# Appeal Decision

**Appeal Ref: APP/R4408/W/15/3139934**  
**Land at Stottercliffe Road, Thurlstone S36 9RF**

- The appeal is made under section 78 of the Town and Country Planning Act 1990 against a refusal to grant planning permission.
  - The appeal is made by Mr Steve Walsh against the decision of Barnsley Metropolitan Borough Council.
  - The application Ref 2015/0535, dated 23 April 2015, was refused by notice dated 24 June 2015.
  - The development proposed is a new dwelling with associated parking.
-

NORTH

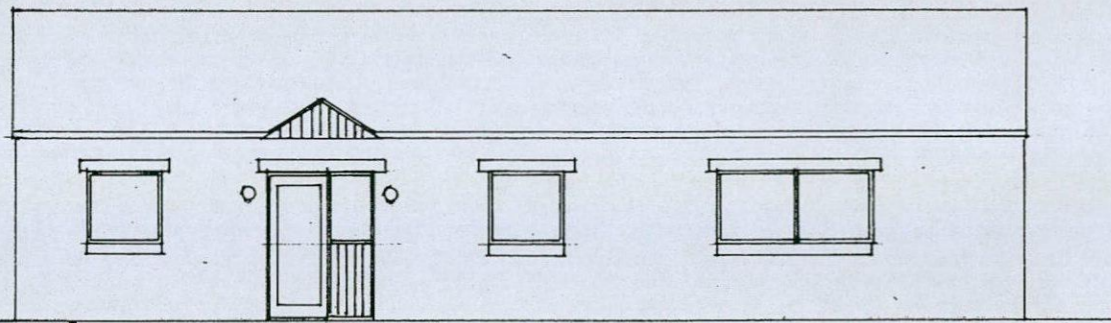
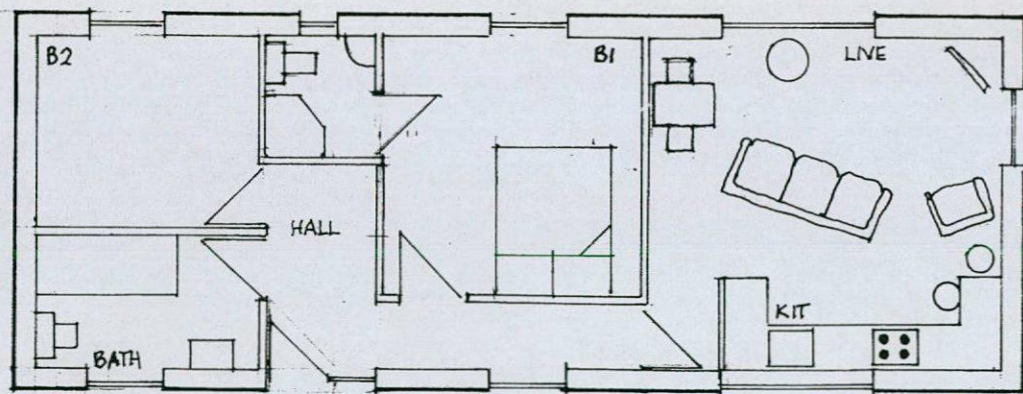
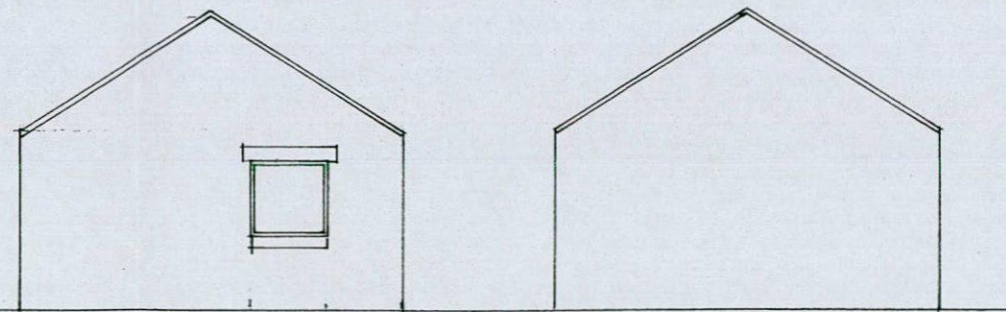
11. The appeal site is located in an elevated position in relation to both No 3 Stottercliffe Road and the properties situated on the A628. The proposed dwelling would have its main windows located on the northern elevation facing the rear elevation of the properties on the main road. Although these are set at a lower level, the elevated position of proposed dwelling would increase the level of overlooking, and the perception of being overlooked, for these properties. As a result it would reduce the level of privacy for the occupiers of

- these houses in both the rear gardens and the first floor rooms that have windows on the rear elevation.
12. The proposed windows would also overlook much of rear garden area of No 3. Whilst at present this area is largely covered in a variety of outbuildings, should in future the occupiers of this property wish to utilise this area for more formal garden use, it would be overlooked from the proposed dwelling.

13. Whilst I am satisfied that adequate boundary treatments could be provided to prevent the overlooking of the rear widows of No 3 from the garden area of the proposed bungalow, the position of the rear elevation immediately adjacent to the boundary would mean that a similar solution could not be utilised to prevent the overlooking of the properties on the A628, or the garden area of No 3, without having a severely detrimental impact on the outlook from the proposed windows.

21. The appeal site is a long narrow site, and the appeal property would occupy the full depth of the site. Although a limited amount of garden space would be provided to either side of the building, the circulation spaced around the house would be limited. As a result, and in contrast to the more open and spacious feel of the surrounding area, I consider the development would appear cramped and over developed. This would have a detrimental impact on the character and appearance of the area. In addition, the combination of the elevated position of the site, and its prominent position on the access road, means the dwelling would appear overly dominant in the street scene.

PLAN

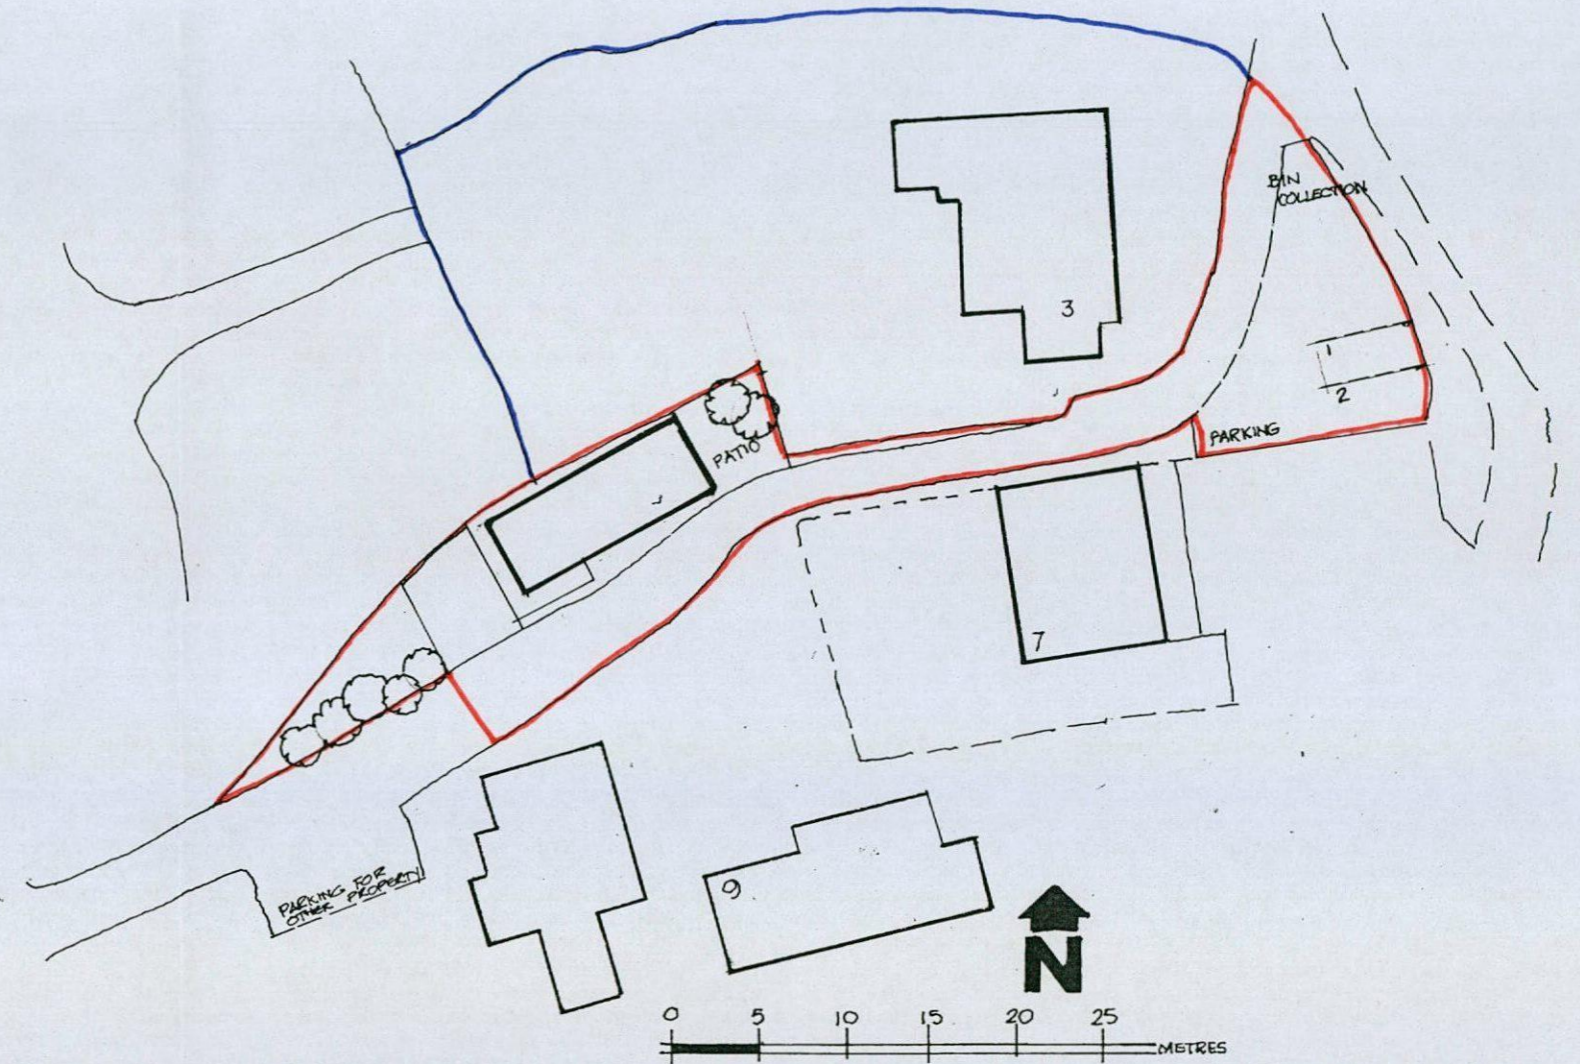
7. I note that the appellant has suggested a parking space could be provided to the west of the site for 'emergency' use. However, this is not shown on the plans, and would have implications for the amount of garden space provided. As such I consider it would be a materially different scheme to that which is before me at this appeal.

17. The proposed bungalow would have a number of windows that would face towards the access road. These would be largely windows serving non-habitable rooms. Given this, and the fact that pedestrian and vehicular movements in front of the house would be limited in number, I am satisfied that the level of overlooking would not be detrimental to the living conditions of future occupiers. Moreover, I observed that the situation would not be significantly different to some of the other houses on the main road who have windows immediately adjacent to the pavement.
